Your Ref: OWPC16277
Our Ref: BR/294/17/PL 30-10-2017
Please ask for:
Ross Leal

Removal of existing external fire escape & erection of rear single storey extension.

21 Lennox Street Bognor Regis

Proposed

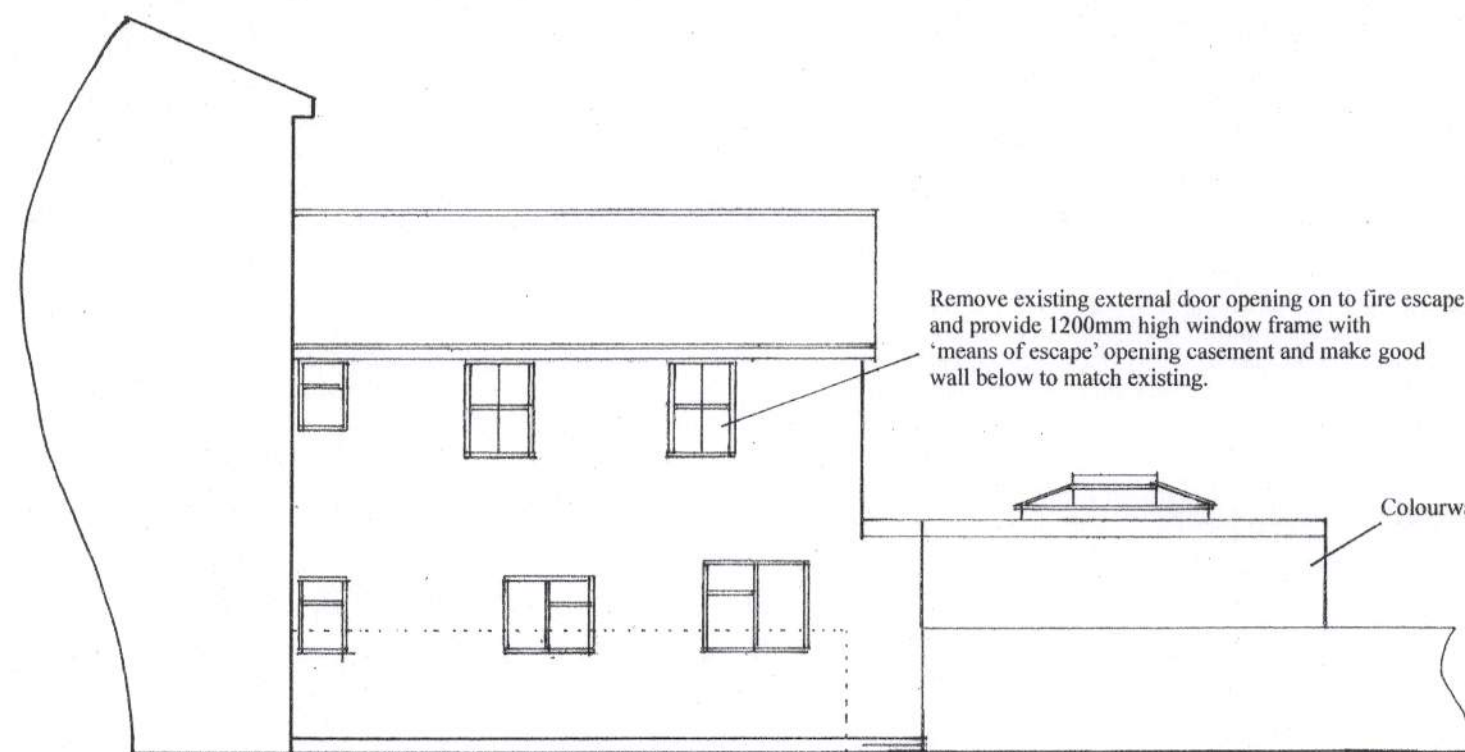
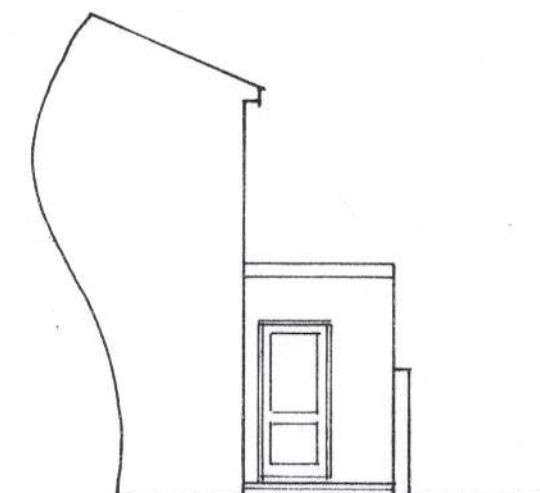
- 1. The building will be much higher than the existing party wall and block light.*
- 2. The adjacent existing brick built waste and recycling bin storage area next within Mountbatten Court next to the party wall will be very close to the new building and will likely be identified as a fire risk on our next fire risk assessment. We have no other area to relocate the bins.*

- 3. The windows at the back of the proposed extension will overlook the party wall and will cause intrusion of privacy to the Ground floor and first floor flat bedroom windows of D block.*

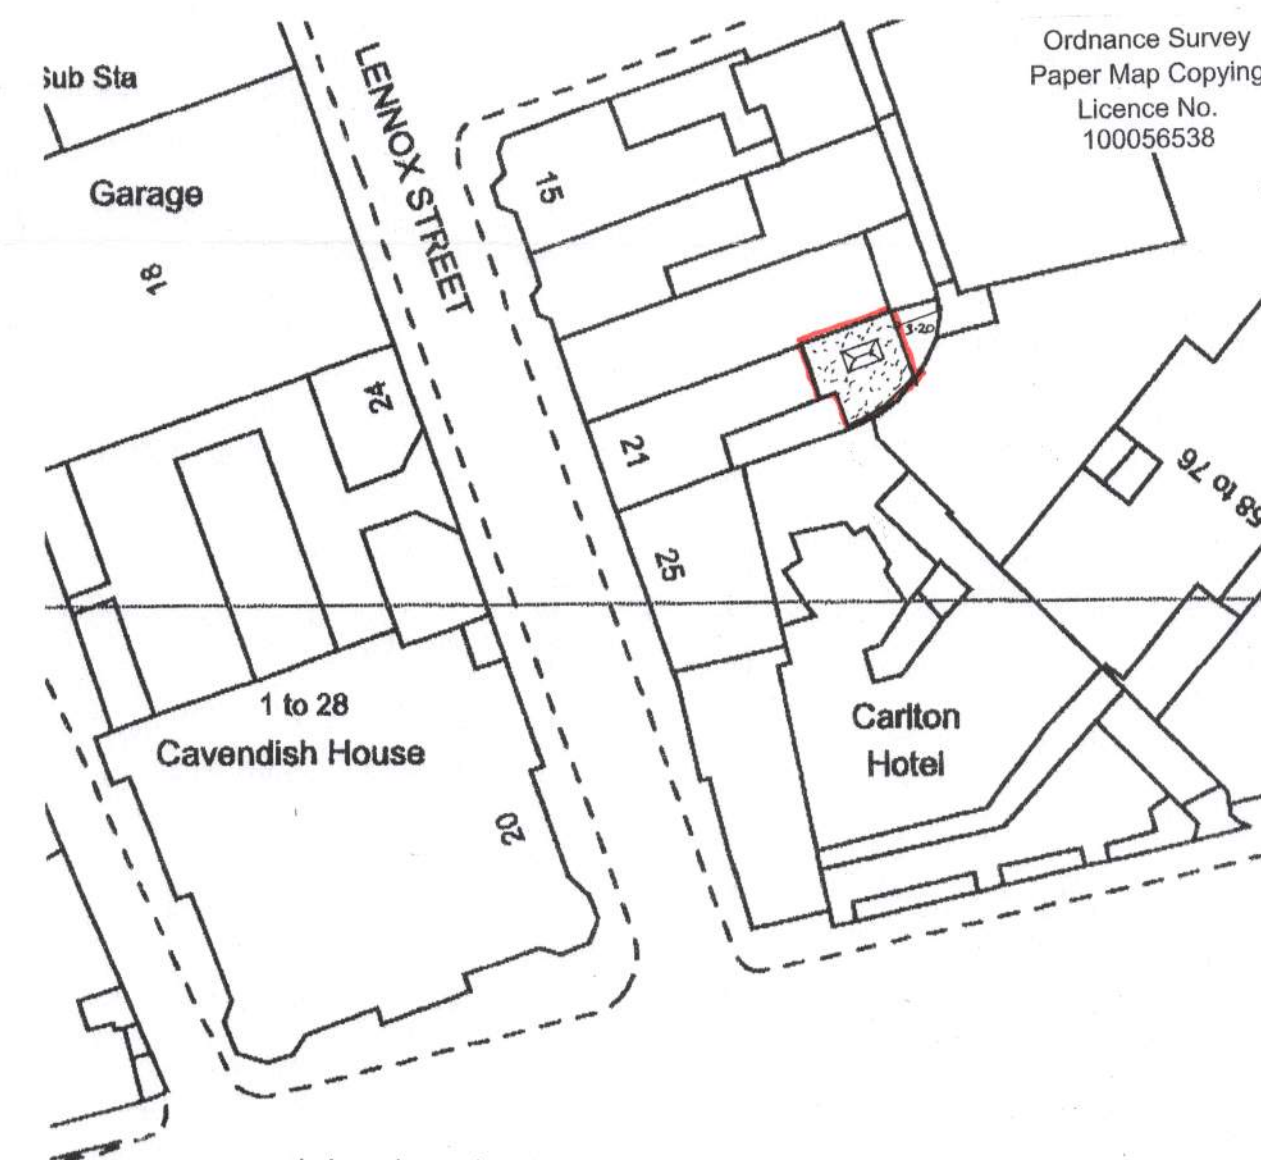
- 4. We understand the property at 21 Lennox Street is currently converted and used as self contained flats. Removal of the fire escape may pose a safety threat to the occupants.*
